CITY OF ALBUQUERQUE

December 16, 2021

**RE: Champion Xpress Car Wash
1520 Juan Tabo Blvd. NE
Grading and Drainage Plan
Engineer's Stamp Date: 11/03/21
Hydrology File: J22D031**

Based upon the information provided in your submittal received 11/03/2021, the Grading & Drainage Plan is **not** approved for Building Permit, SO-19 Permit, and for action by the DRB on Site Plan for Building Permit. The following comments need to be addressed for approval of the above referenced project:

C-3.1

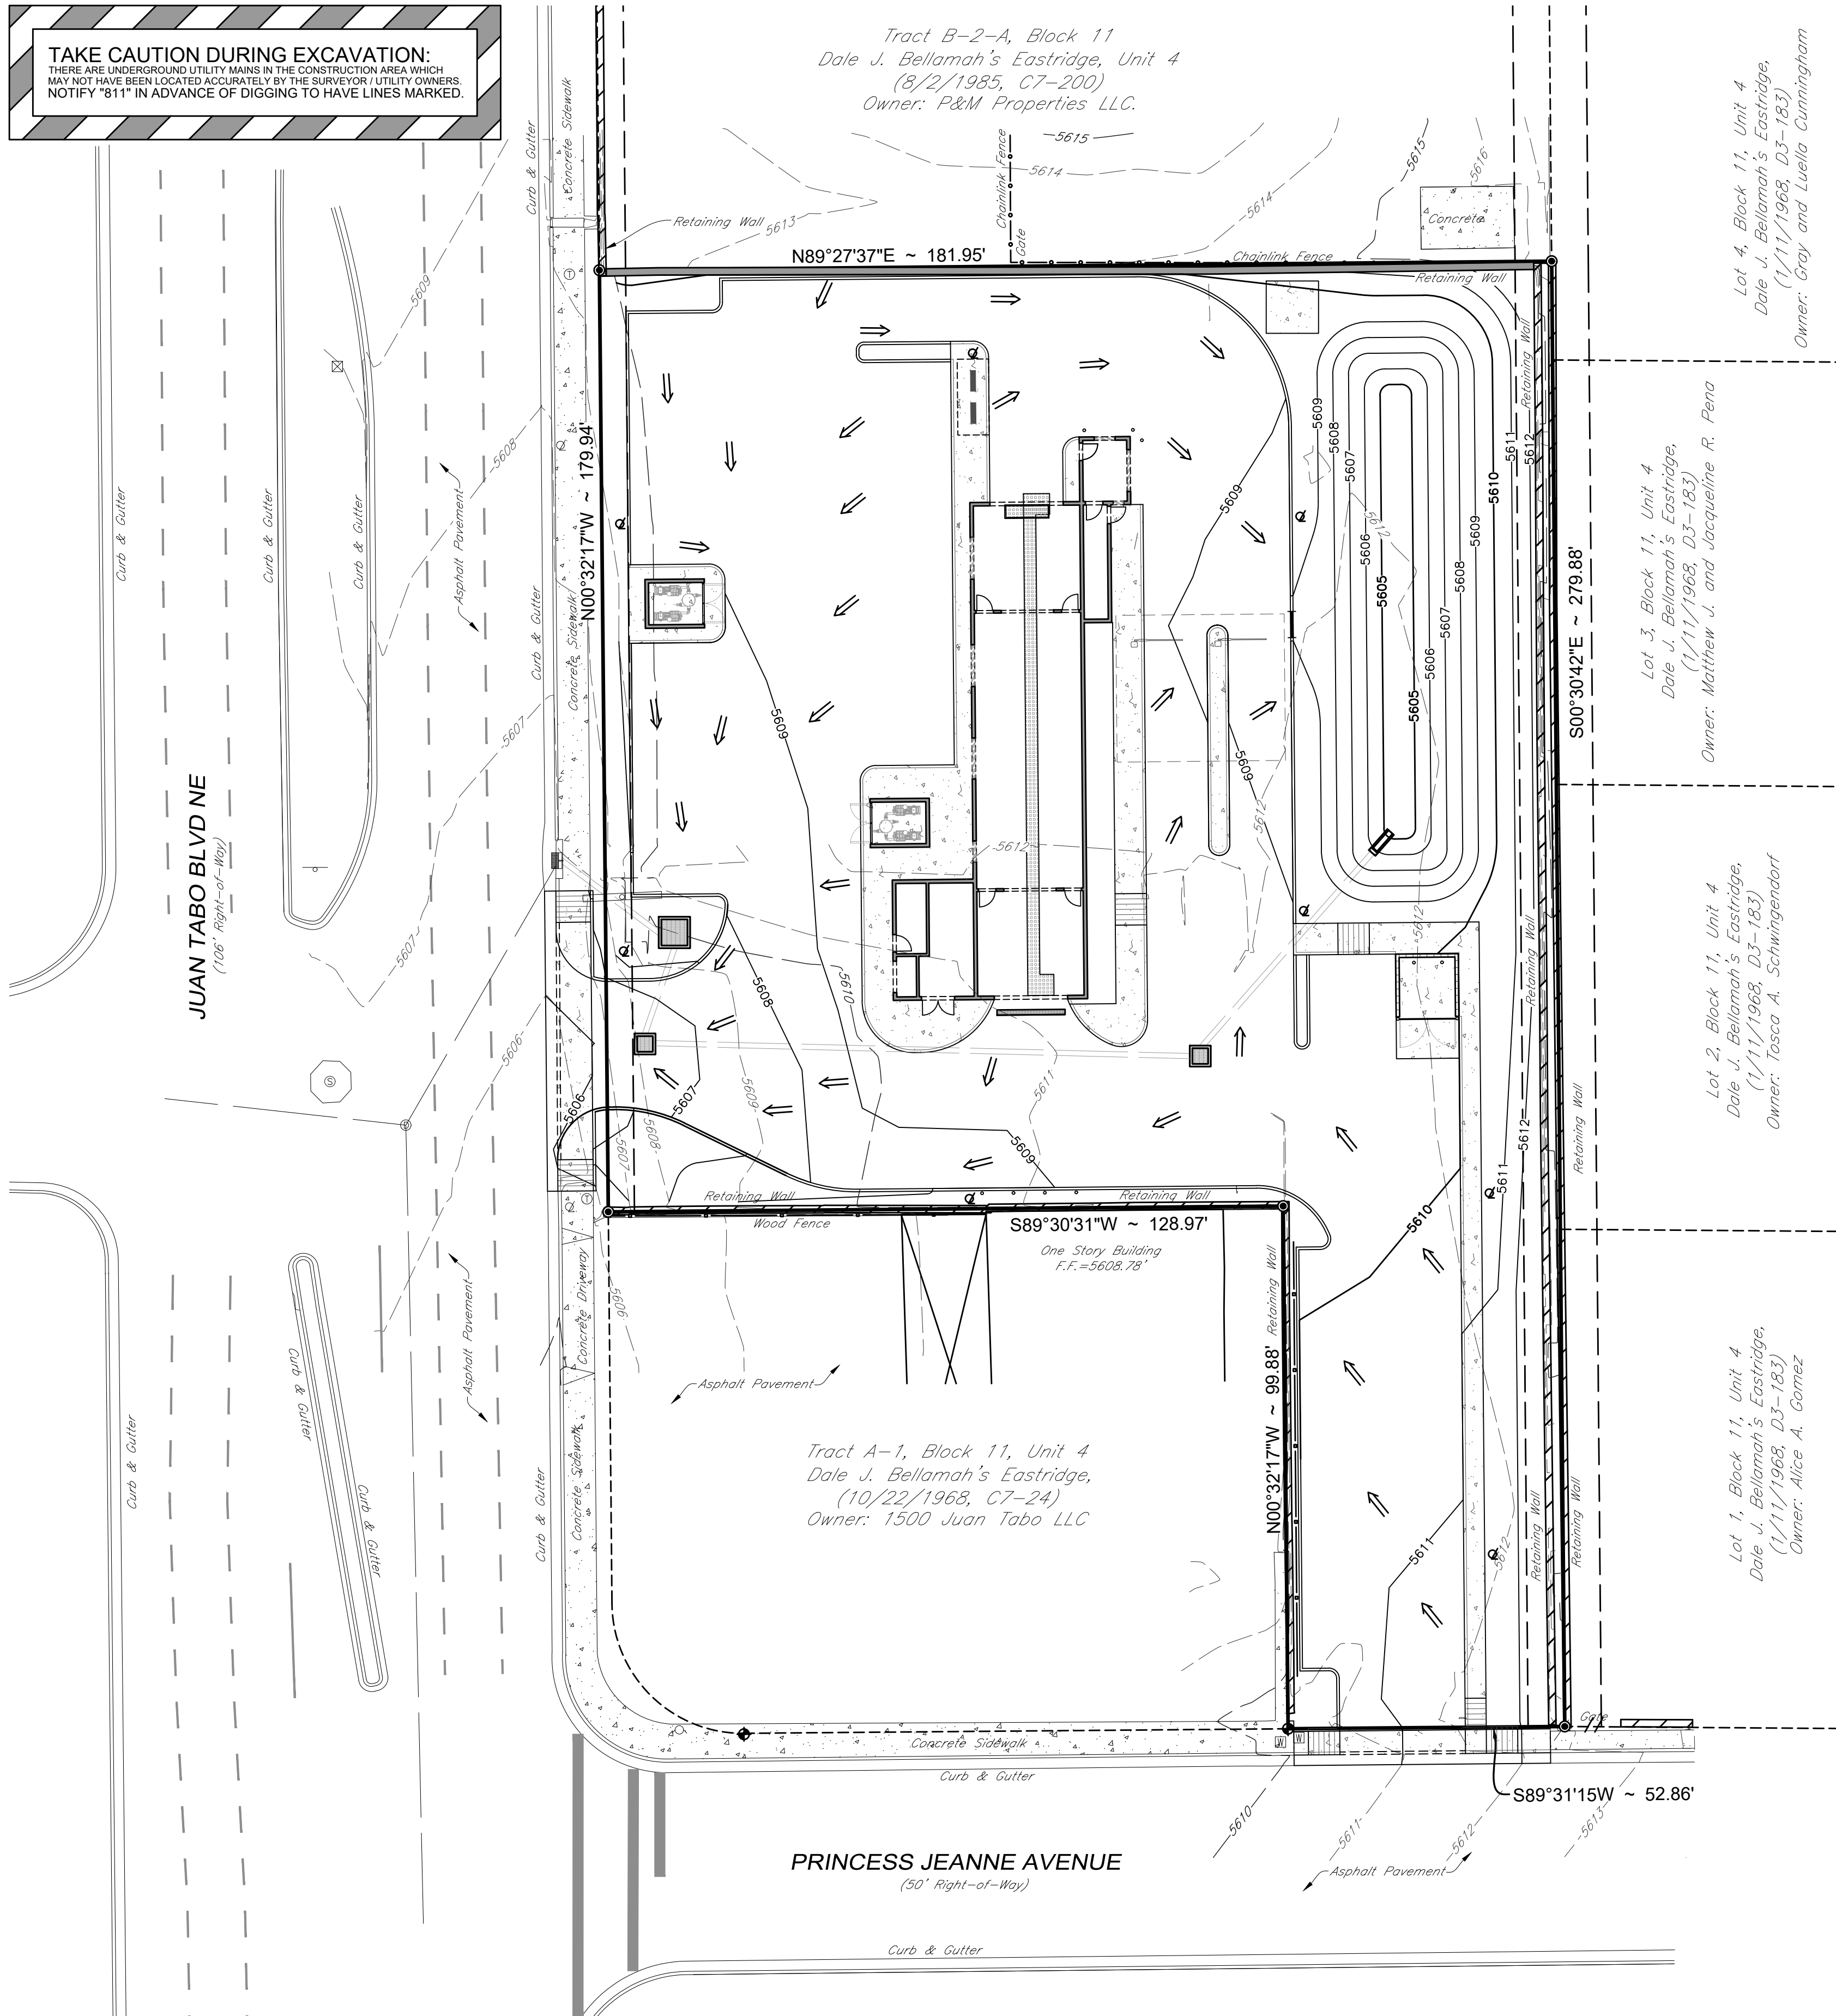
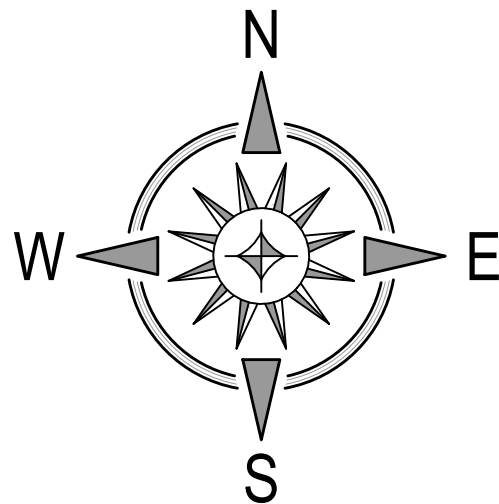
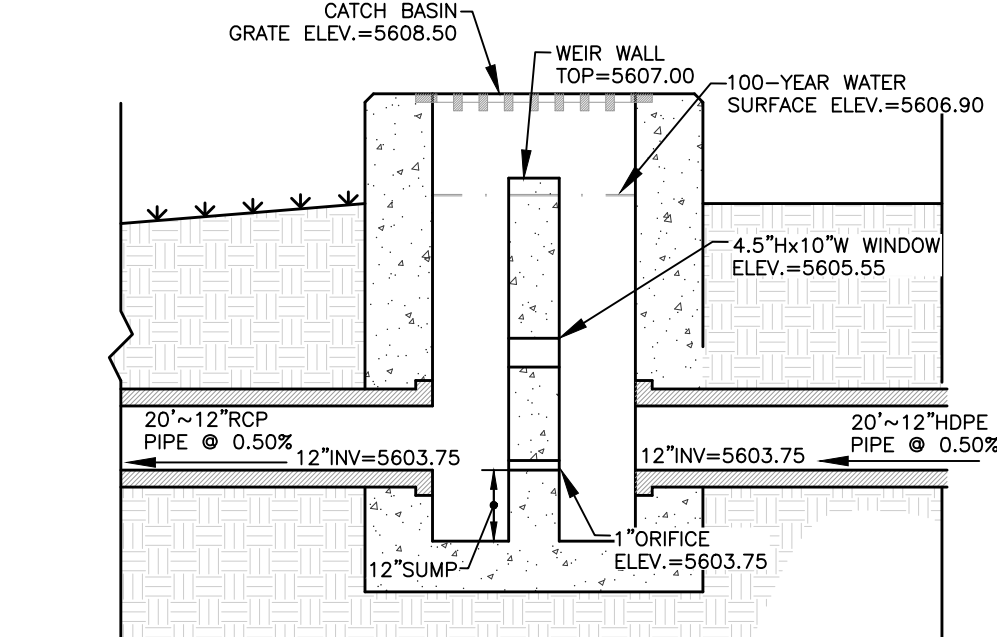
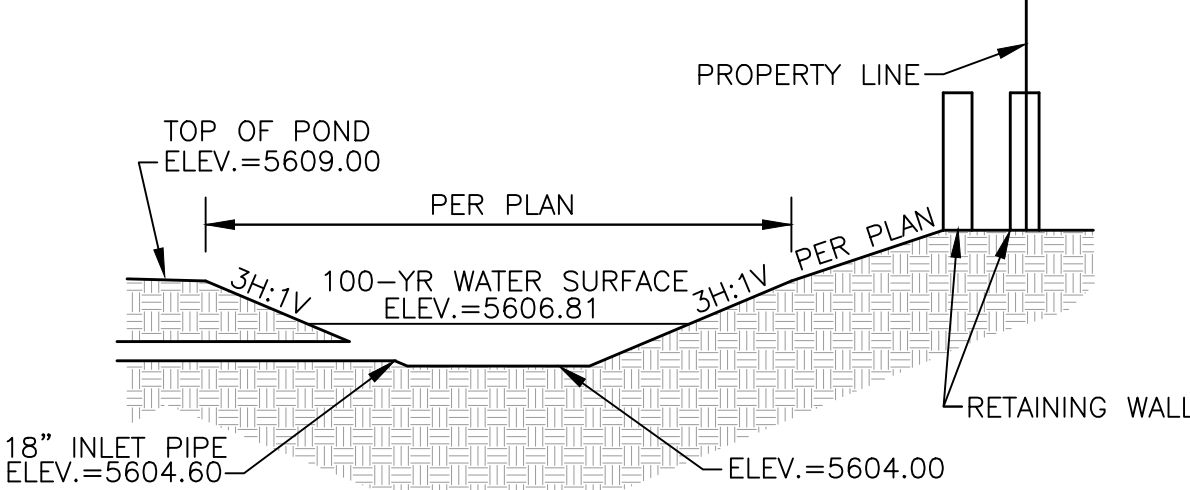
1. Please provide the weir calculations, per DPM Article 6-16(A), for the curb cuts and sidewalk culverts. A coefficient of 2.7 is typically used for the weir equation $Q = CLH^{2/3}$.
2. The proposed entrances need to follow standard details. Please see CoA Standard Detail 2426. Check with Transportation.
3. Please update the SO-19 Notes. See Attachment.
4. Update reference to updated DPM and go over calculations as details have changed in the new DPM. Ensure numbers are updated in the associated tables and information based on new DPM values.

- b. Please use the procedure for 40 acre and smaller basins as outlined in Development Process Manual (DPM) (signed 06/08/20) Article 6-2(a). Please provide both the existing conditions and proposed conditions for the 100 year-6 hour storm event.
5. Include details of the outfall structure at the pond.
6. Include details of all the inlets at grates. What Type? Standards?
7. Please utilize RCP for the section of pipe connecting to Juan Tabo Blvd. HDPE for the remaining sections is fine.
8. Refer to previous/existing G&D for the site and call out 20% Free Discharge and follow that information.
9. A water block, 0.87' high, per COA Paving Detail No. 2426, is required at the driveway entrances. Please utilize this detail for the entrances.

10. Please add a note under Grading Notes. "Side slopes need to be stabilized with Native Grass Seed (per City Spec 1012) with Aggregate Mulch or equal (Must satisfy the "Final Stabilization criteria" CGP 2.2.14.b.)".
11. Provide a detail of the pond including property line, inlet and to include volume and max water elevation.
12. Include weir and orifice calcs.
